RE: AI Job #19034

Project Address: 7911 SE 72nd PL

Subject: Permit No. 2108-084

Fire: (Jeremy Hicks)

Upper Floor Plan

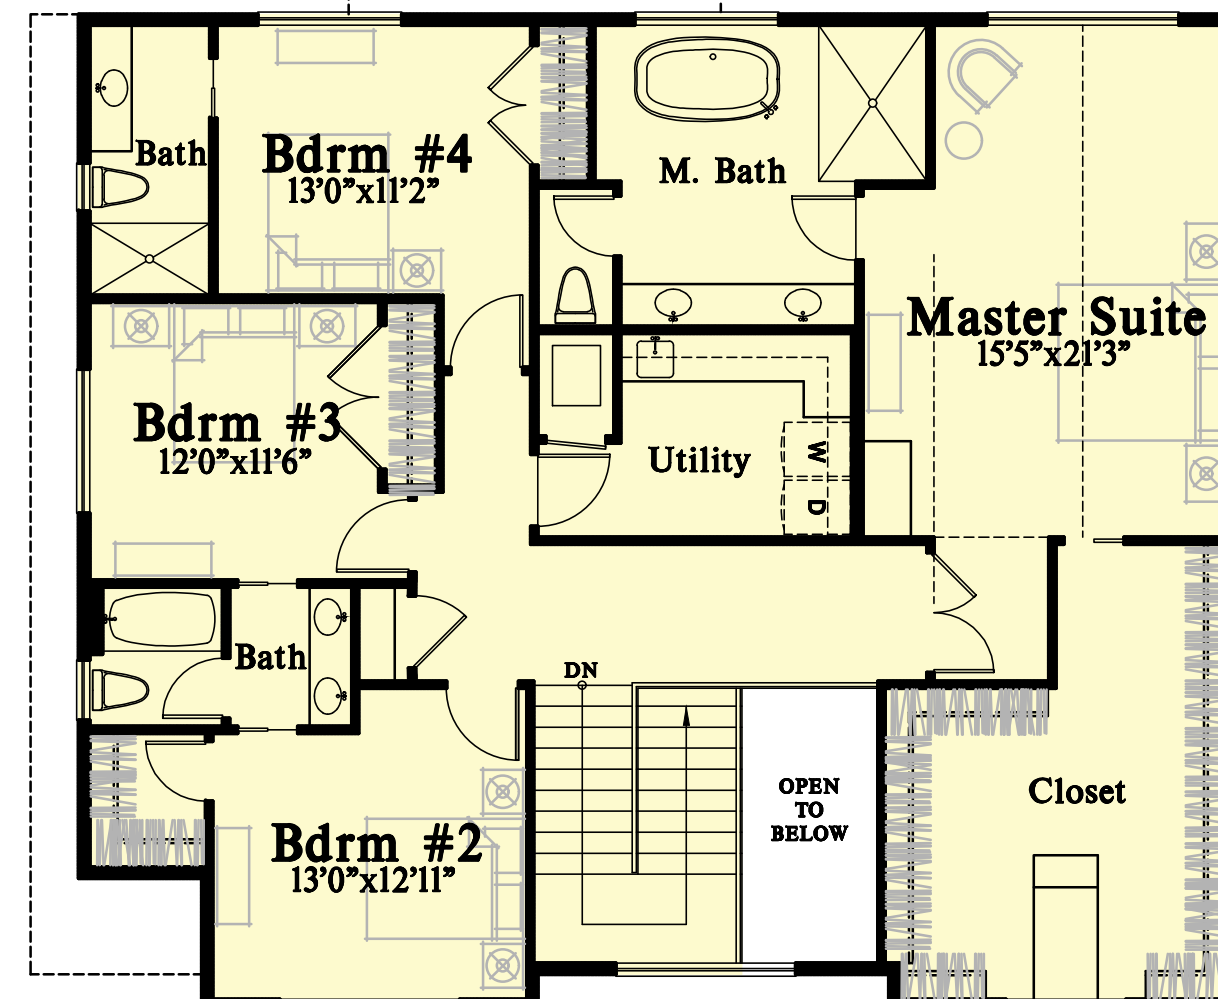
Added a note for the fire sprinkler system requirement on the architectural cover sheet and the site plan sheet A.1..
